BHS Bedfordshire comments on the Virtual Site Inspection Videos

Digital survey 9a (Drone survey)

Drawing Title
**Proposed Site Access
Sheet 1 of 5**

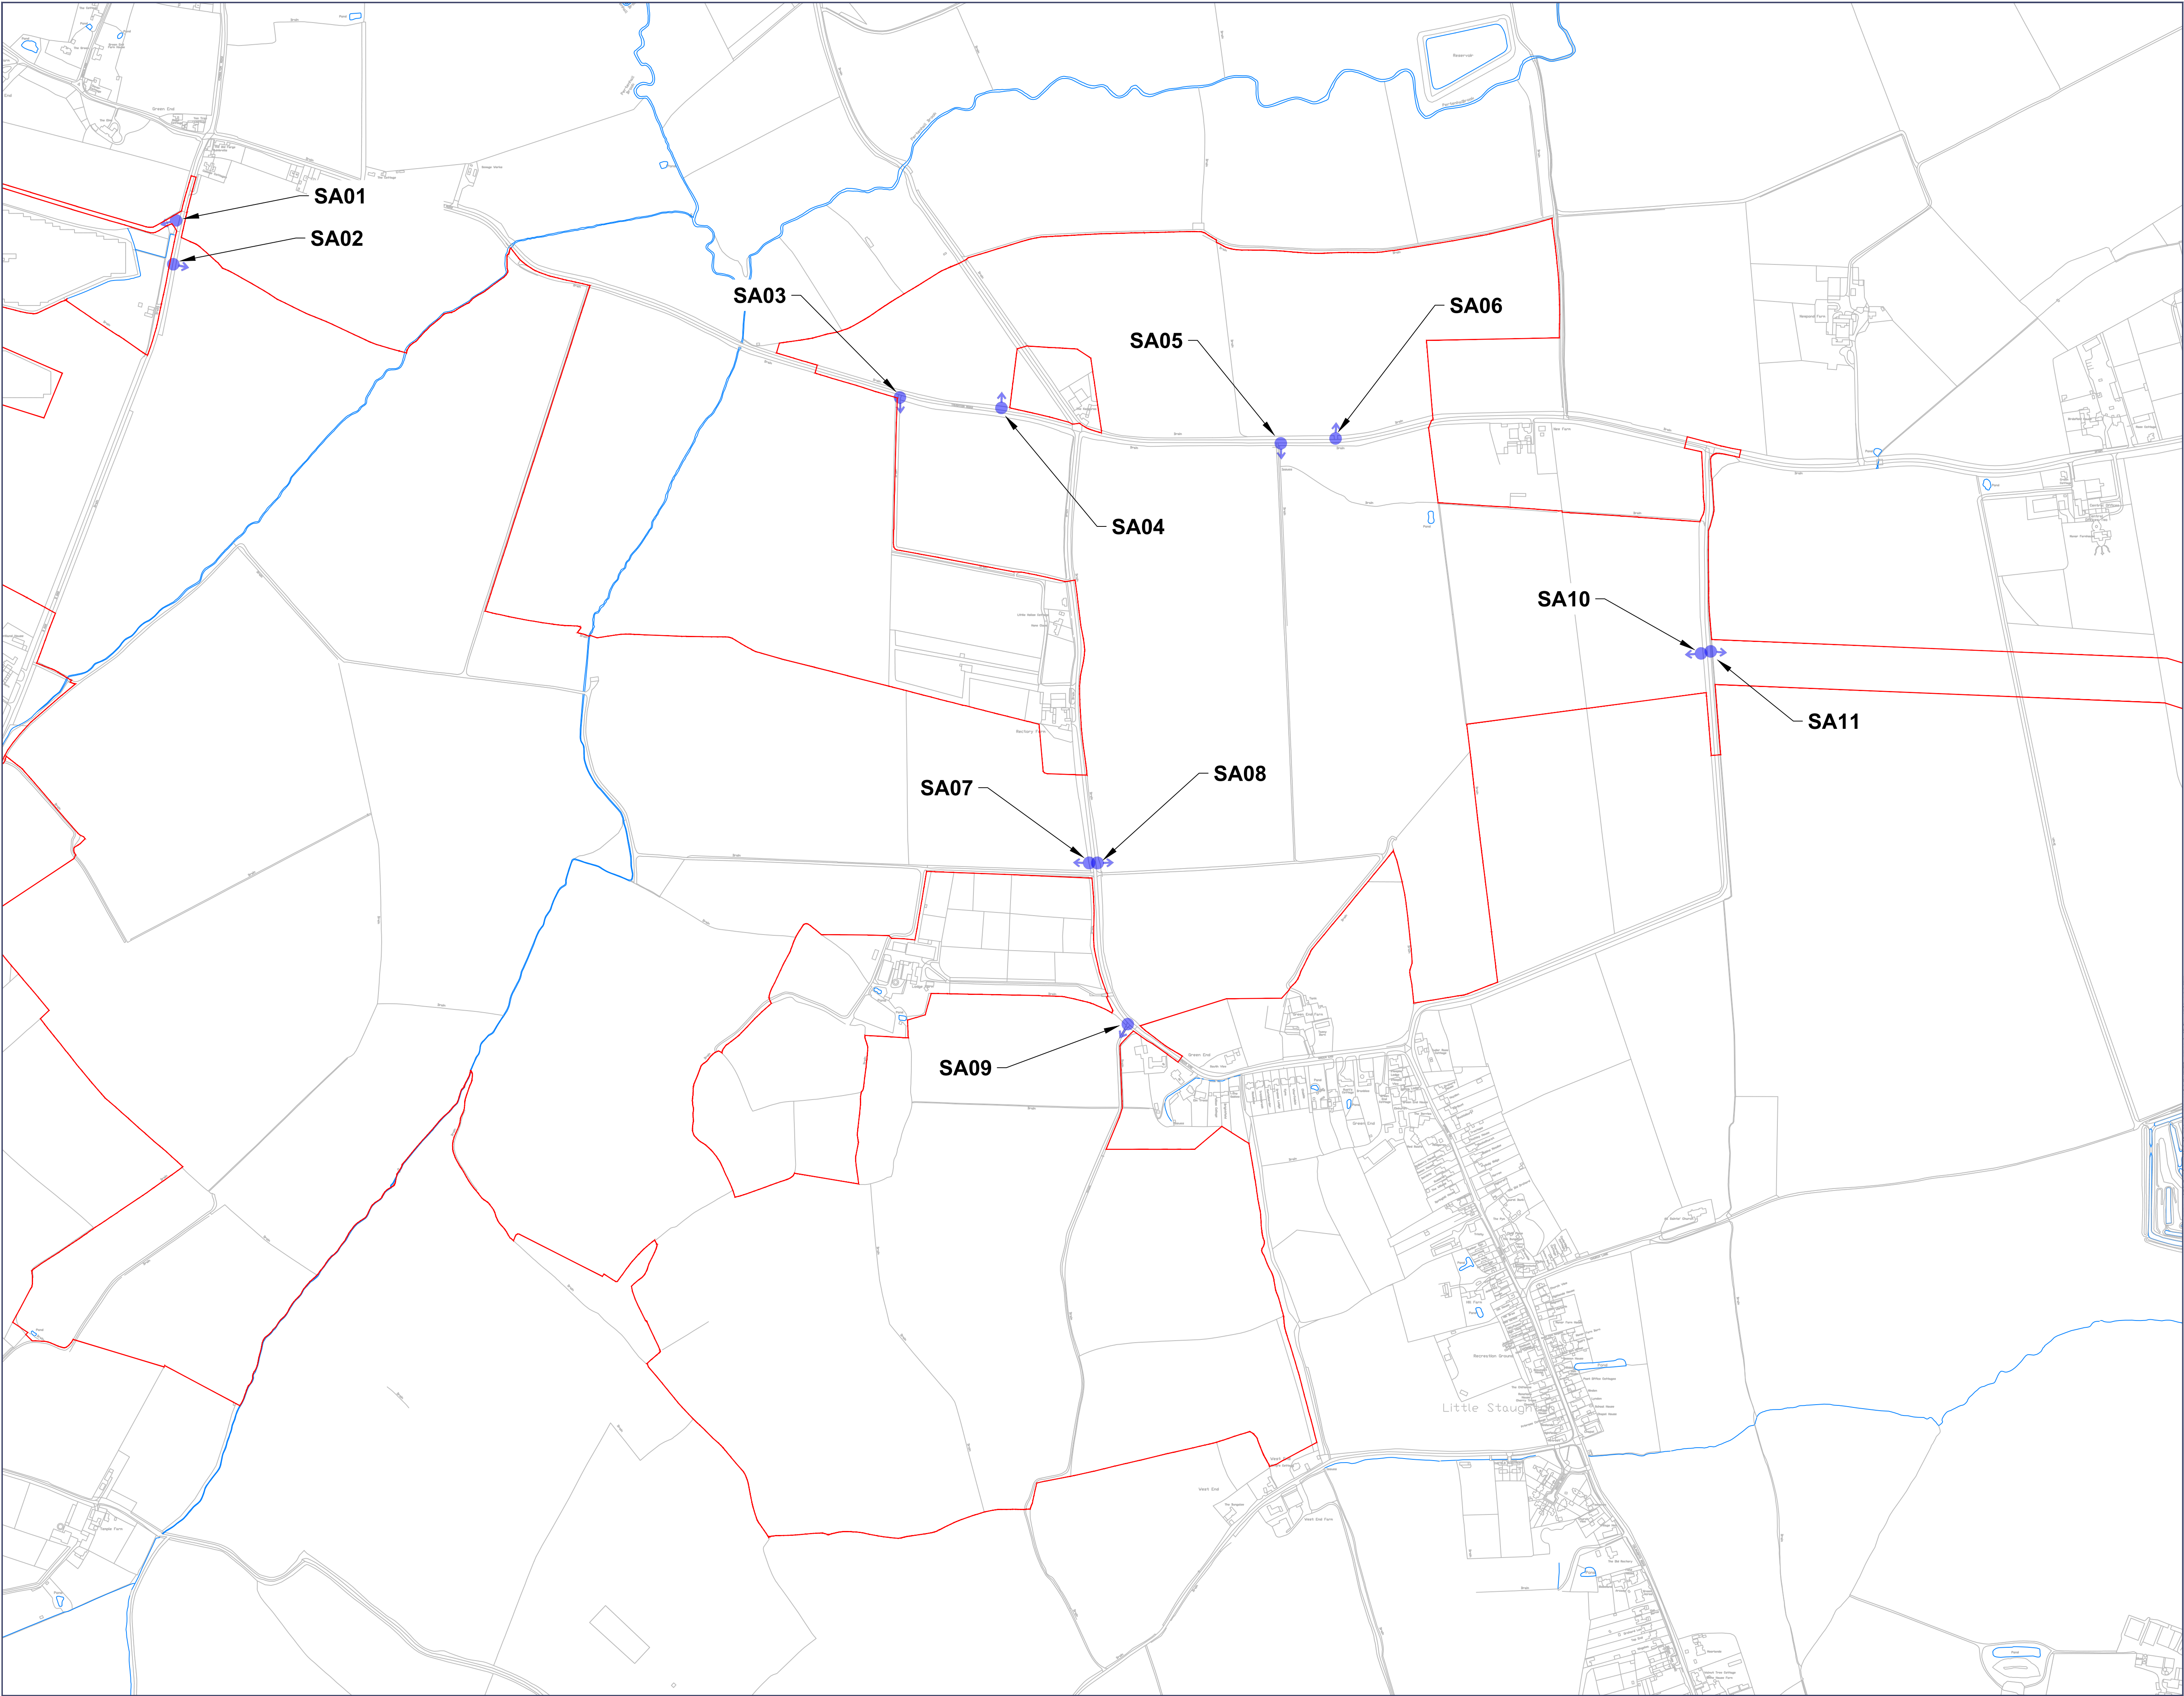
This video shows an ariel view of Pertenhall BW26 close to Manor Farm, a farm track that would also be used as access to Site A with all vehicles entering or leaving the site via the joining track from the B660.

The video clearly shows the two pinch points that create safety concerns for equestrian users of the bridleway. These points were mentioned in both the BHS Beds RR and WR and were more fully described in our submission of suggested locations for the Inspector's site visit (PDA-026).

At 02:56 of the video, the junction of the track from the B660 with the BW can be seen. Note the width of the vehicle track marks and the way that the gravel has been swept onto the verge opposite the access track. All traffic will pass this point and it is intended that a banksman will be in position here. Some traffic may be directed to the left towards the construction up the hill to the west of the site. But the majority will turn right and head, presumably, to the main construction depot for Site A.

A banksman at this point will be able to see traffic approaching from the B660 quite easily, traffic approaching from either direction on the bridleway will only be visible from about 140m away. The safety measures proposed by the Applicant require that HGVs stop 100m away from a horse. Is this feasible?

At 3.16, the narrow width of the left-hand grass verge adjacent to the BW can be seen, and the deep ditch alongside can be identified by the darker vegetation colour at the base of the hedge. Most of the traffic will pass this point.

Should a horse be required to squeeze between a stopped (or indeed moving) HGV at this point there is, in my view, a high risk of an accident. Especially as HGV air brakes can go off at any time, even when stopped.
